Re: BP#2016-02596 - 58 Alder Street Inbox x

Laurie Leader
Plan Review/Code Enforcement
City of Portland, Maine
Inspections Division
389 Congress Street
Portland, ME 04101

ASK-05

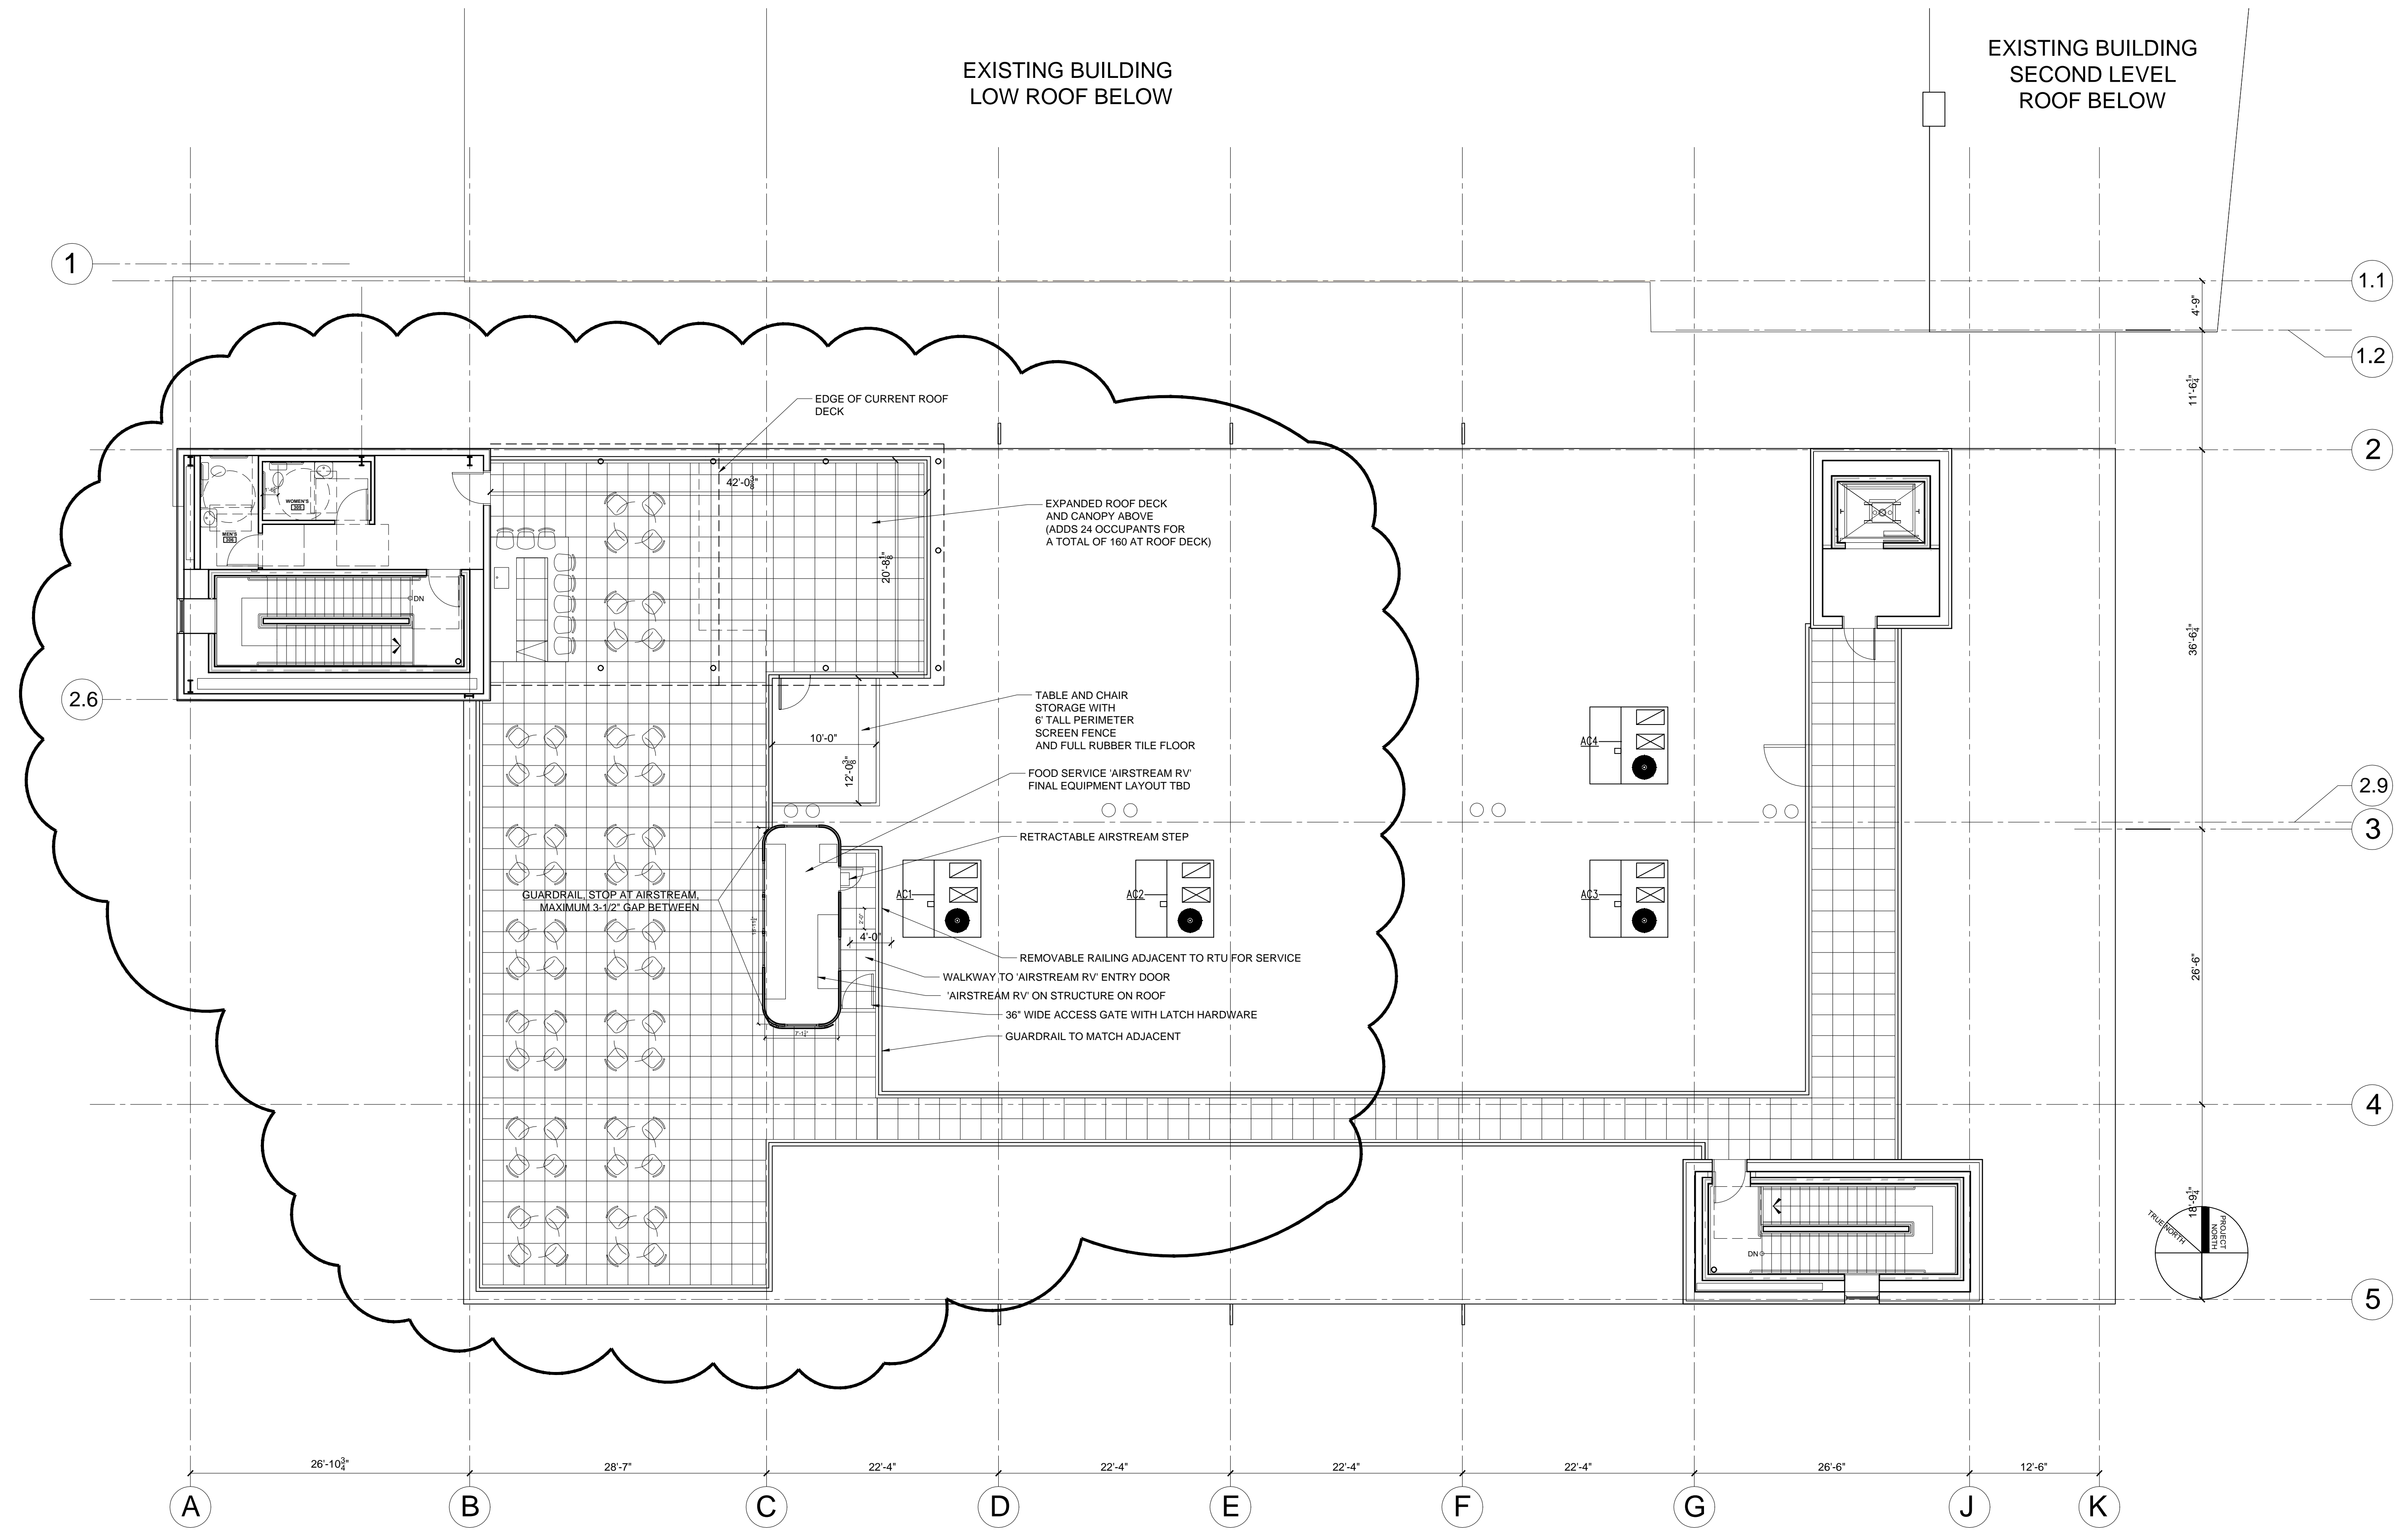
Can you clarify what the RV on the roof top deck will be used for in terms of actual cooking and/or drink preparation? I have copied Eric Cobb or help determine the cities requirements on what the RV will be required to have for kitchen equipment.

- Will you be preparing food in the RV?
- If so, what kind of food prep are you anticipating?
- Will dishes be washed in the RV?

Will you be preparing food in the RV? NO WE WILL ONLY ASSEMBLE FOOD
If so, what kind of food prep are you anticipating? N/A
Will dishes be washed in the RV? NO
